Recommendation Report for Planning Permission

REF NO: BR/74/17/PL

LOCATION: The Kindergarten
86 Annandale Avenue
Bognor Regis

PROPOSAL: Conversion of the ground floor to create 2 No. self contained flats.

Site & Block Plan.

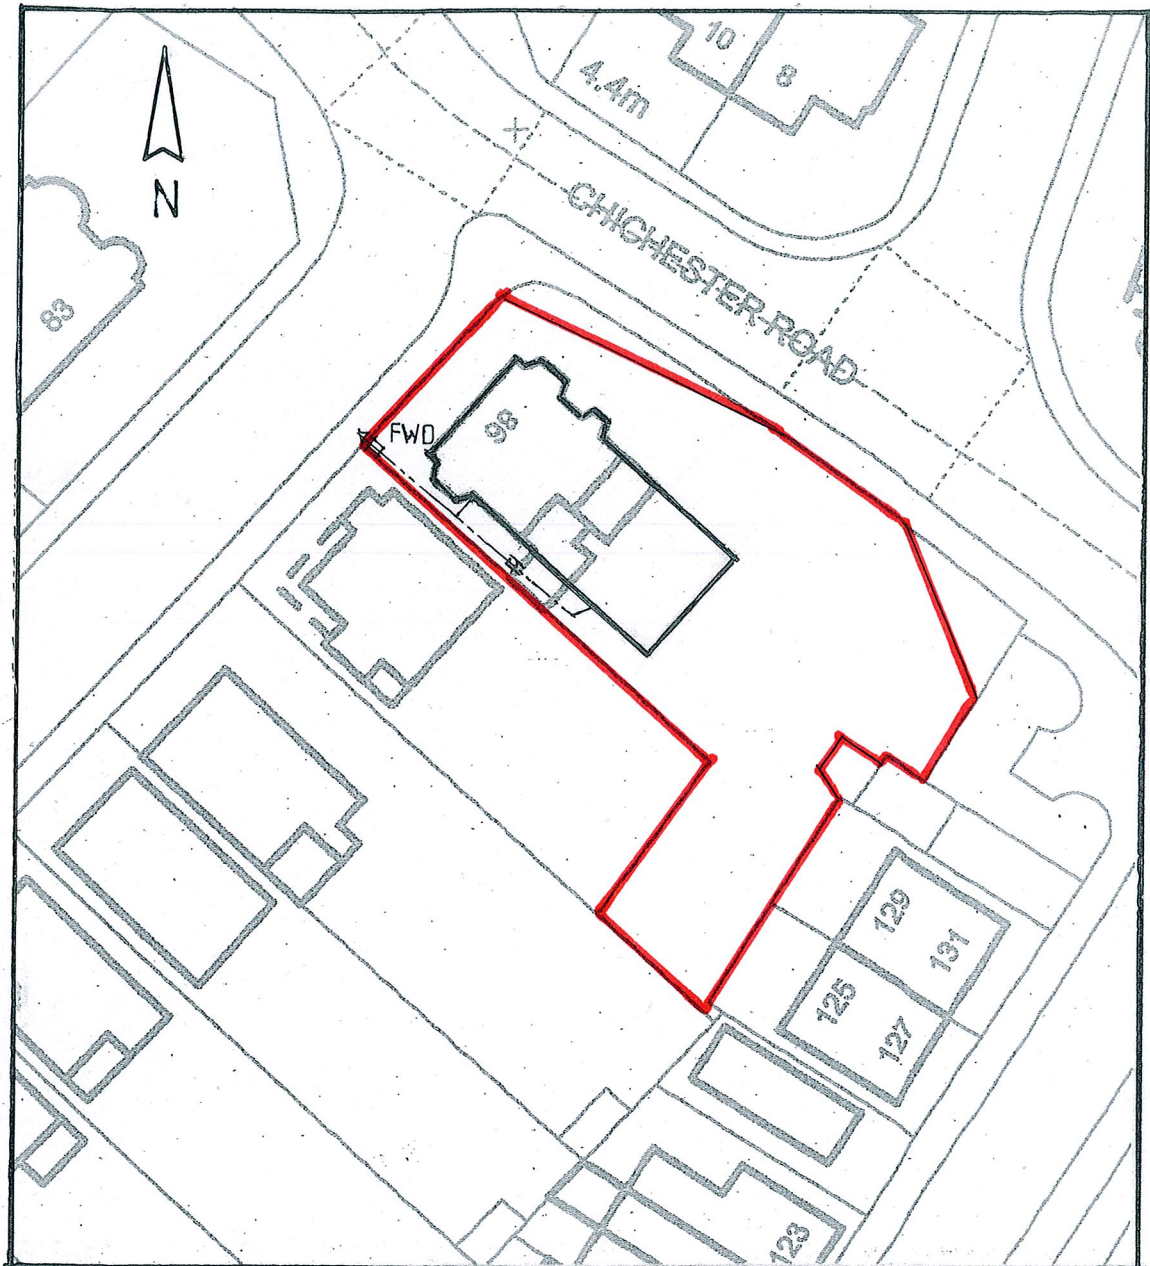
The West Sussex County Council Car Parking Demand Calculator advises that in this location the likely parking demand for 2 x two bedroom flats would be 2 spaces. There is space within the site for the parking of 1 vehicle but this has not been allocated to any of the flats. However, WSCC Highways consider that the site is sustainably located such that residential occupiers will not require a car to access local shops and services. Furthermore, any overspill on-street parking could not take place in locations that would be detrimental to highway safety due to comprehensive junction protection markings.

Proposed Ground Floor Plan

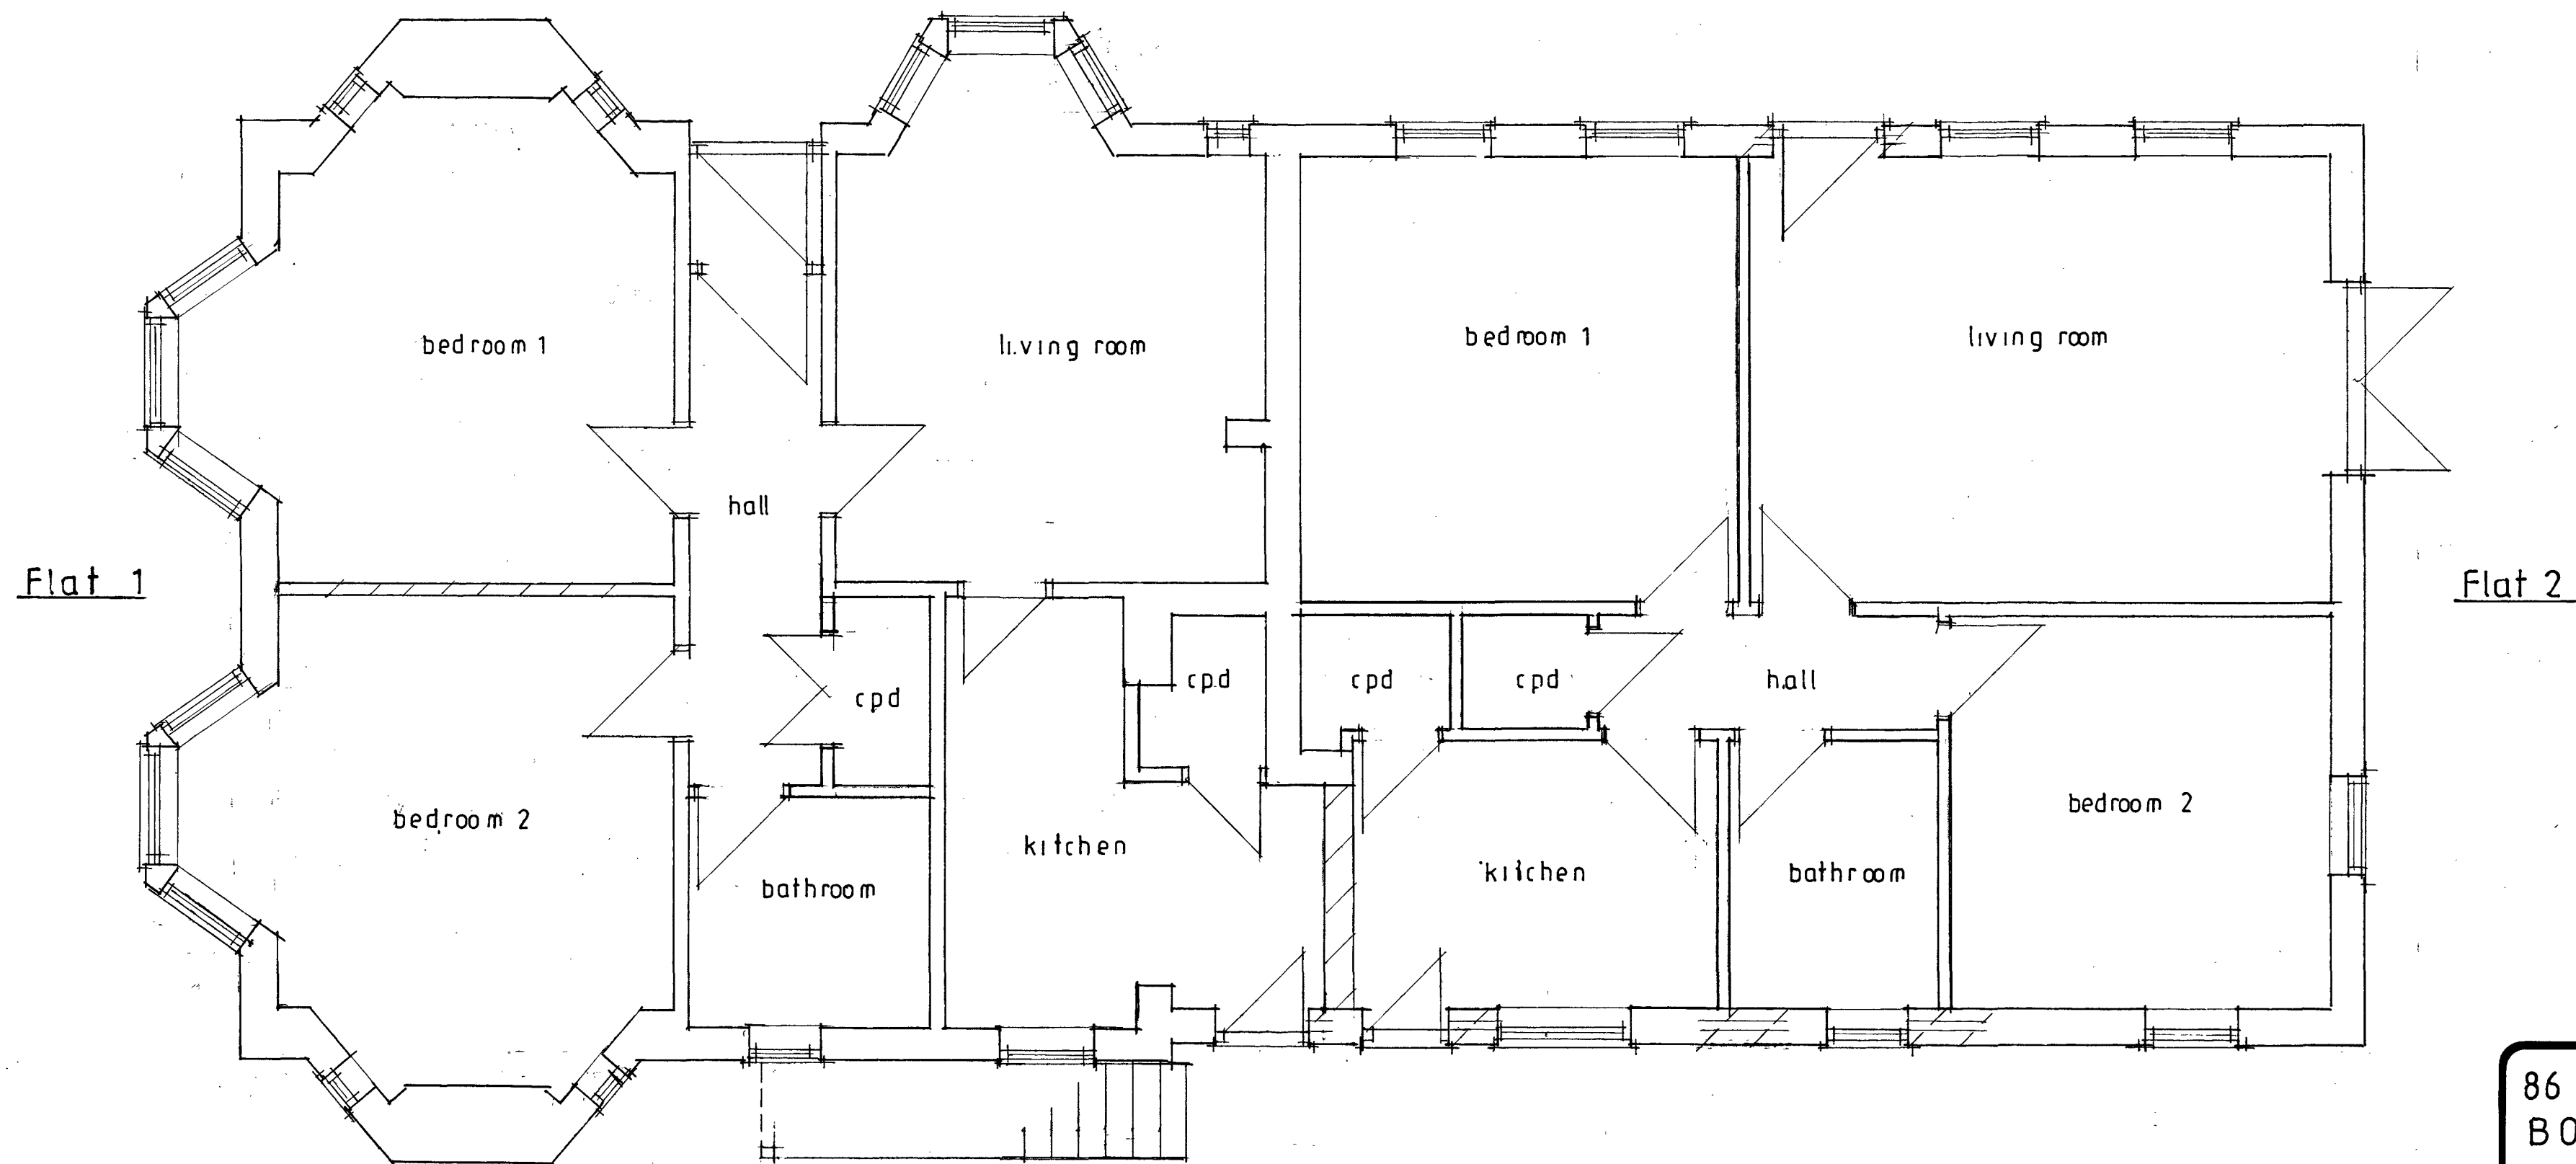
- A room where the only escape route is through another room is termed an "inner room" and poses a risk to its occupiers if a fire starts unnoticed in the outer room. The escape routes from the bedrooms in Flat 2 is via the kitchen or living room, this can be overcome by ensuring that the window in the

bedrooms are escape windows and adequate fire protection within the flat.

The only proposed new openings are to the ground floor and views from these will be screened by existing boundary treatments. Environmental Health officers have not raised any concerns as to how the arrangement of rooms in the two flats relate to each other.

local plan (publication version) which has been approved by the Council for development management purposes and subject to testing at appeal. The Policy states that 2 bed flats should have 5 square metres of private amenity space and that this should ideally take the form of either private garden, patio, balcony or roof garden. Neither flat has access to any private space but the applicant has confirmed that all of the flats within the building will have access to the large gardens to the rear which is considered to offer a sufficient standard of amenity space. Flat 2, in particular will have secondary doors opening onto this garden.

PROPOSED ELEVATIONS

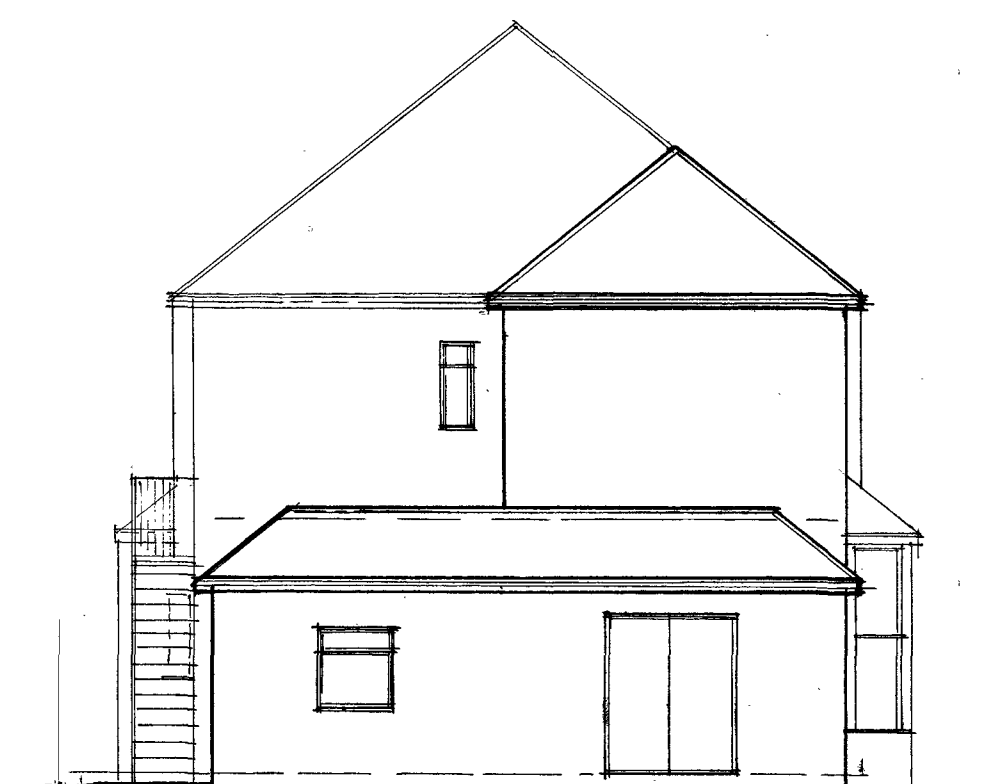
Each flat will have 2 bedrooms and a share of the large rear garden. No allocated parking is provided. External alterations are limited to an additional door on the northeast elevation, door replacing a window on the southwest elevation and replacement of two ground floors windows also on the southwest elevation.

The proposed change of use complies with GEN22 in that the change of use does not result in the loss of the building but rather preserves it with the potential for future external repair works. The proposed alterations are considered to be minor and are not considered to adversely affect the appearance of the building.
